Written representation after Open Floor Hearing on 25th Feb 2025 Ashford International Hotel at 5pm

DRAWING TITLE	<p align="center"><b>FIGURE 7.7: NON-DESIGNATED HERITAGE ASSETS: PREHISTORIC TO ROMAN</b></p> <p>APFP Reg. 5(2)(m)</p>				
---------------	--	--	--	--	--

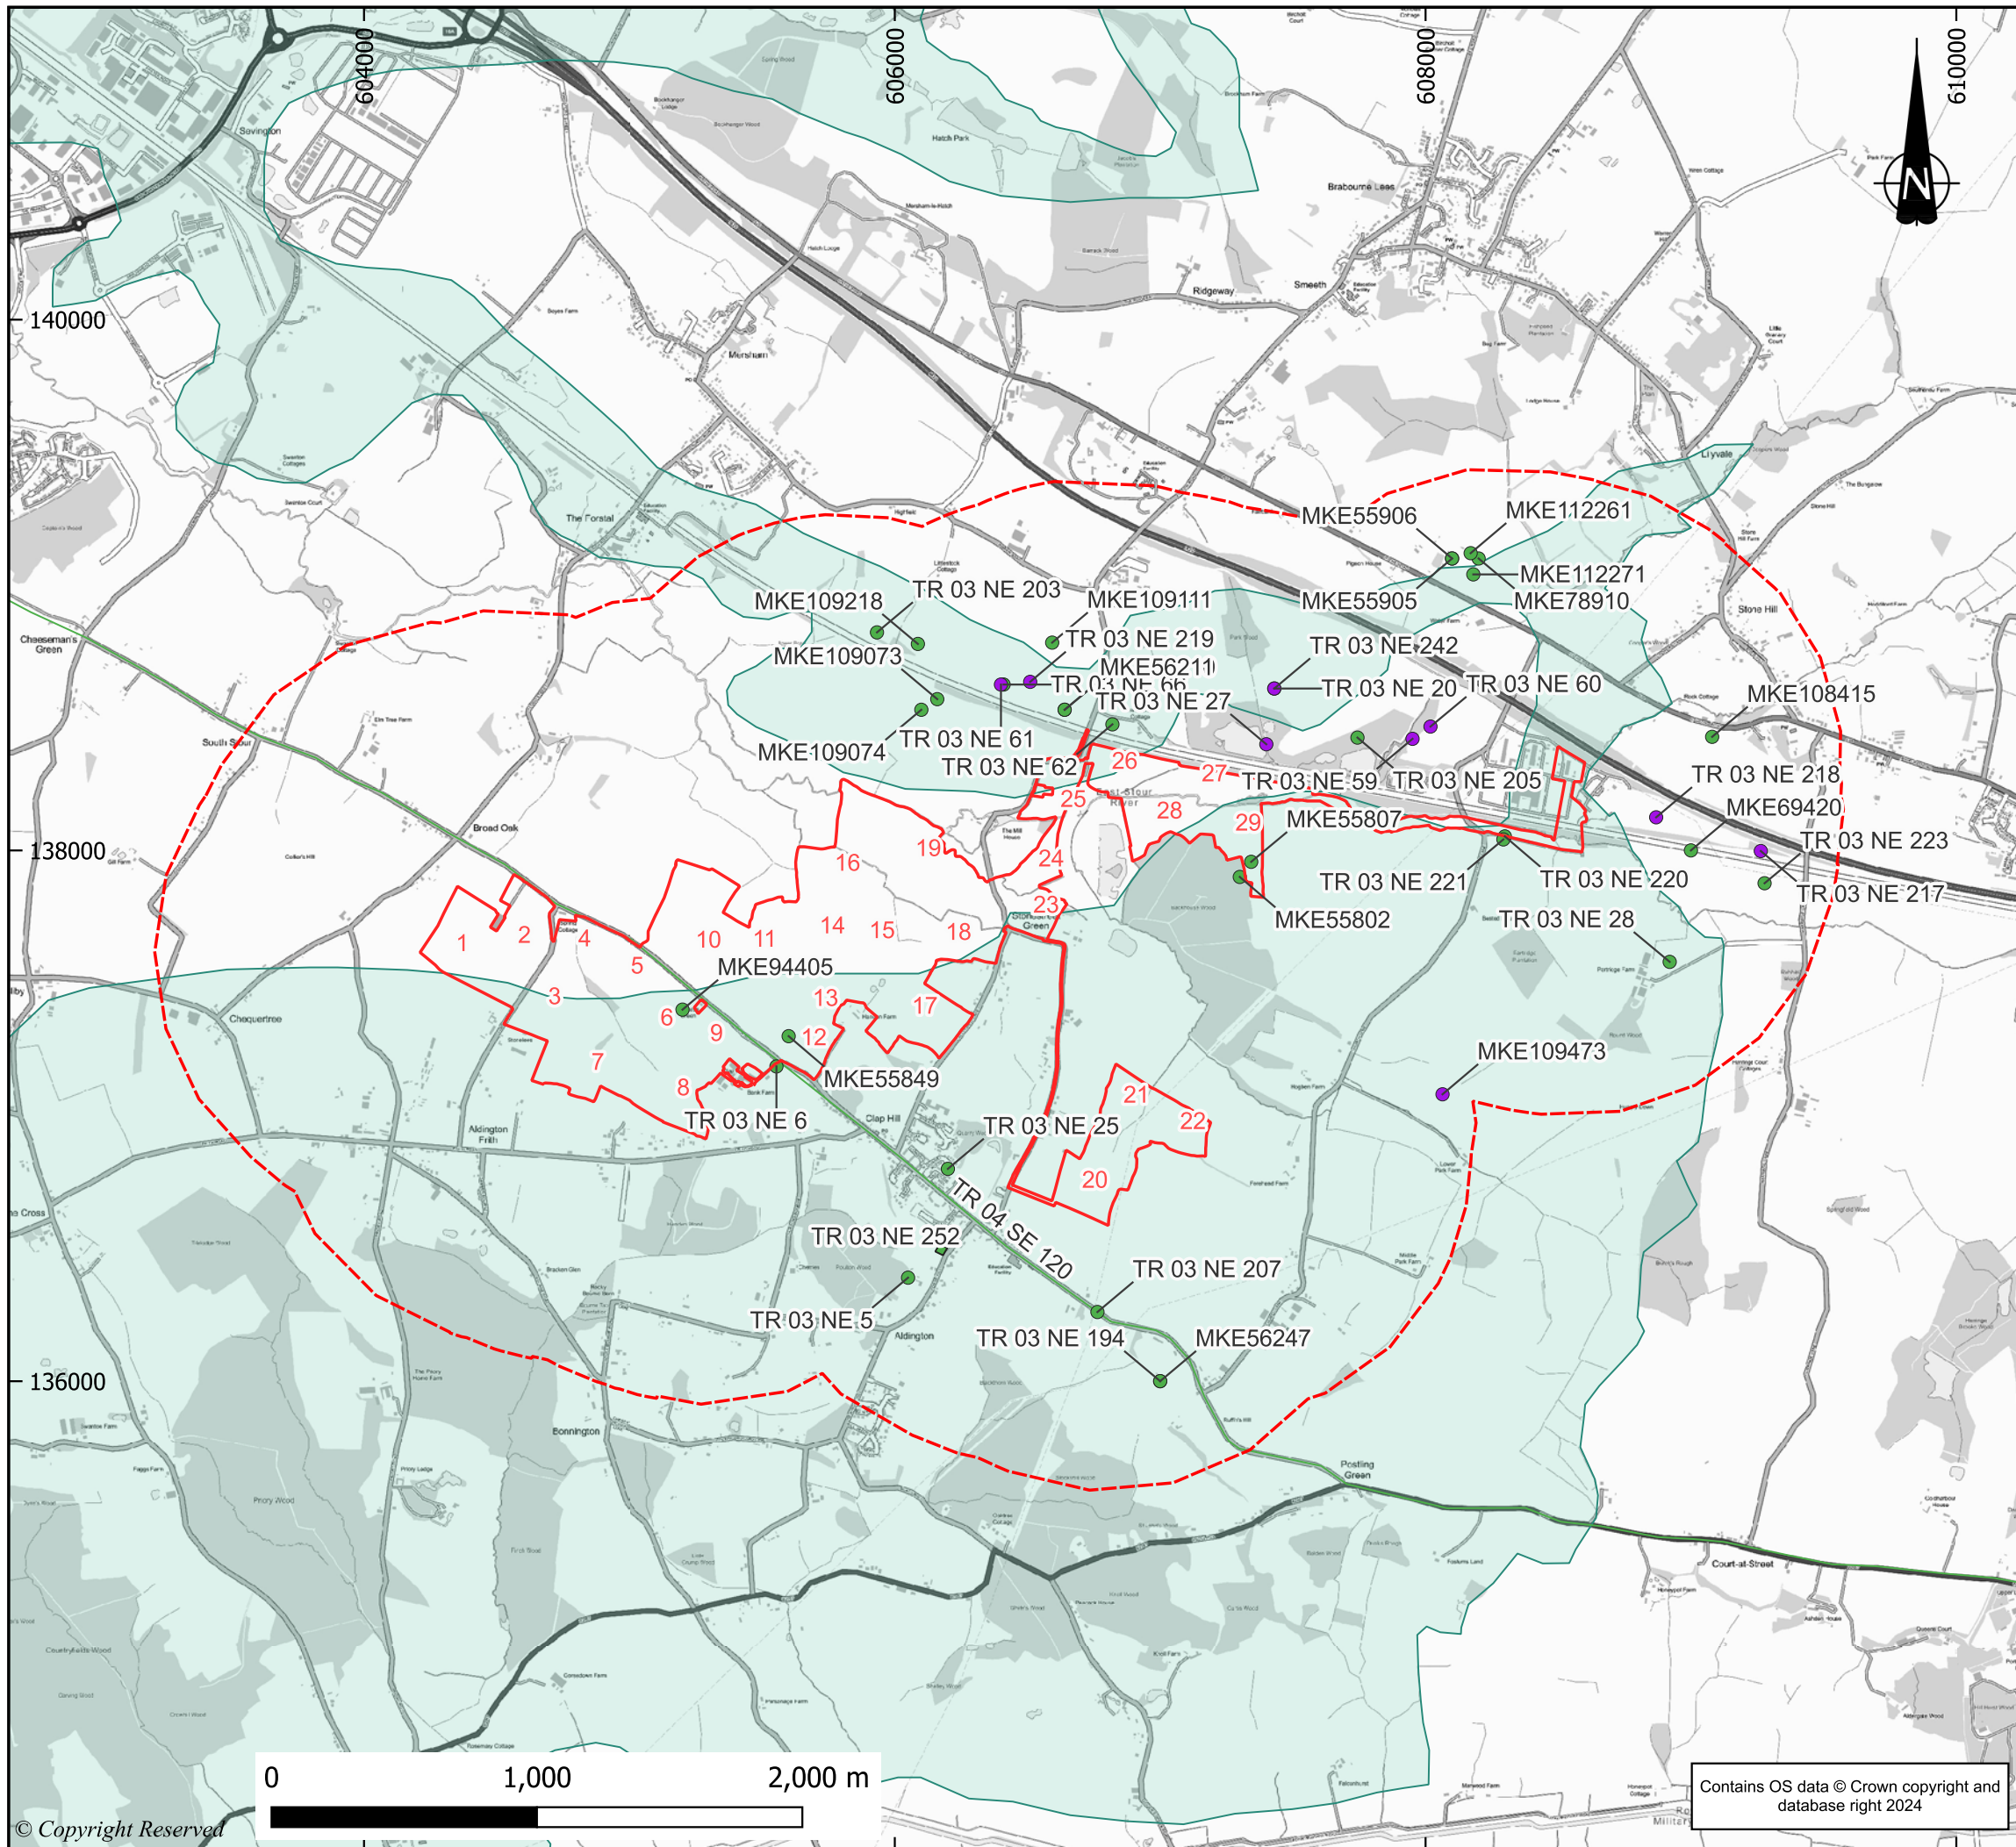
On the Kent HER (historic environment record) there is an interesting crop mark which appears square and on discussion with several archaeologists with many years of experience in Kent, the general feeling is that this could well be another potential villa site.

How is it then that Wardell Armstrong could effectively write this off with just the comment that while it is noted, it is of unknown origin, date etc. Well, I might just say of course it is if you don't bother to even look at it archaeologically by at least putting a trench down to have a look at it!

DRAWING TITLE  
**FIGURE 7.11:  
SUMMARY OF ARCHAEOLOGICAL EVALUATIONS  
UNDERTAKEN**

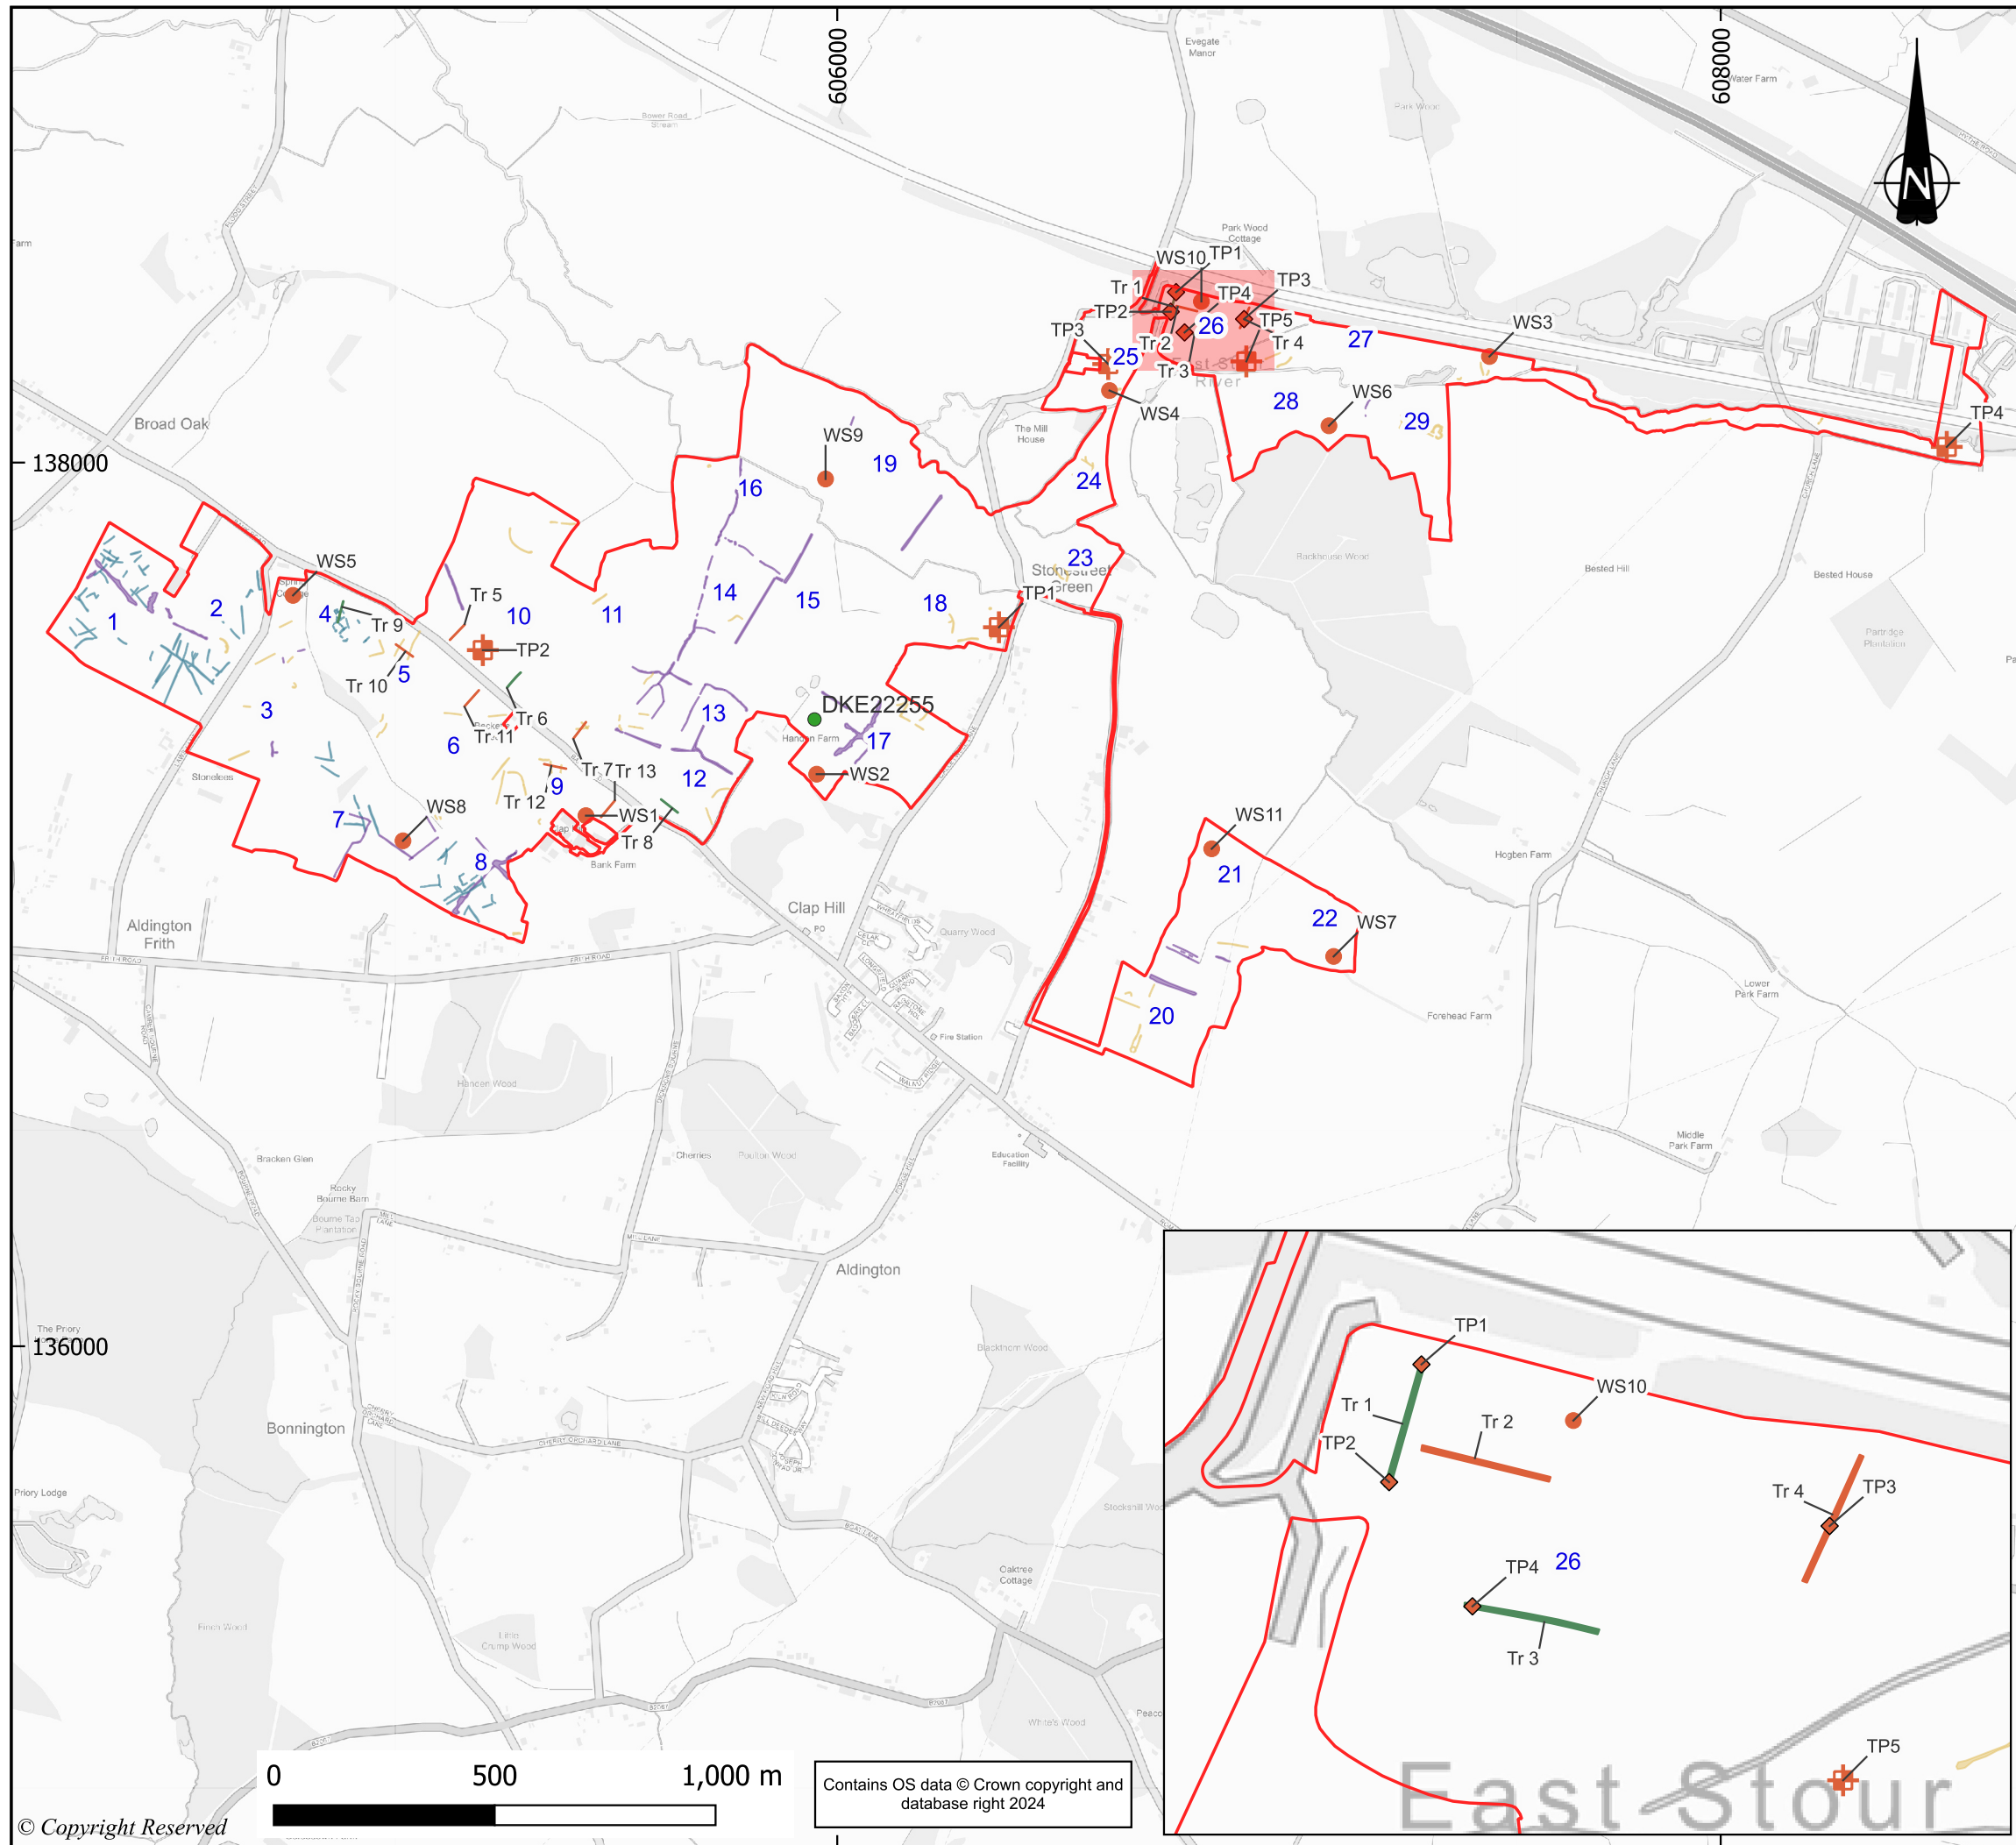
I was made aware that Evolution Power were 'ordered' to put in more trenches as the sheer paucity of the work they had done was effectively thrown out by KCC. It seems they have been commissioned to do about another 60 trenches in various places across the site. In total that would mean they have now done about 75 trenches in total. Nationally I believe the recommendation for archaeological trenching across a site is 5% of the site area using 50m x 2m trenches. Judging by the amount that Evolution Power have done this is far less than the official recommendation which I believe should be at least 200+ trenches of this size.

When the barrister was asked about this, he said that the trenches were being dug in areas where they thought that archaeological evidence was likely to be found. My feelings about this are that surely this is not the way to sample a site properly particularly as geophysical surveying can be notoriously inaccurate/unreliable and it is not until you actually dig into the ground that you can begin to unpick whether or not people from our historical past lived and worked the land in and around the village of Aldington or anywhere where the landscape is threatened by development of any type which will destroy that evidence both now and for future generations to come.

I feel that to allow the developer to both limit and choose the criteria for the siting of the trenches, albeit with some advice from possibly the KCC archaeological team seems very wrong and suggests a very biased approach to work to disprove anything rather than to actively work to do the best they can not to destroy the largely undiscovered history of this very unique landscape.

The very least Evolution Power could do now, is step up to the plate and put things right, do a proper, at least 5% full random trenching of the site giving due consideration to looking at areas of high archaeological possibility and maybe offering the chance of a community partnership to look at the history of the area and maybe a community excavation such as has been done at the Chilmington housing development where there is an ongoing partnership with AOC archaeology group
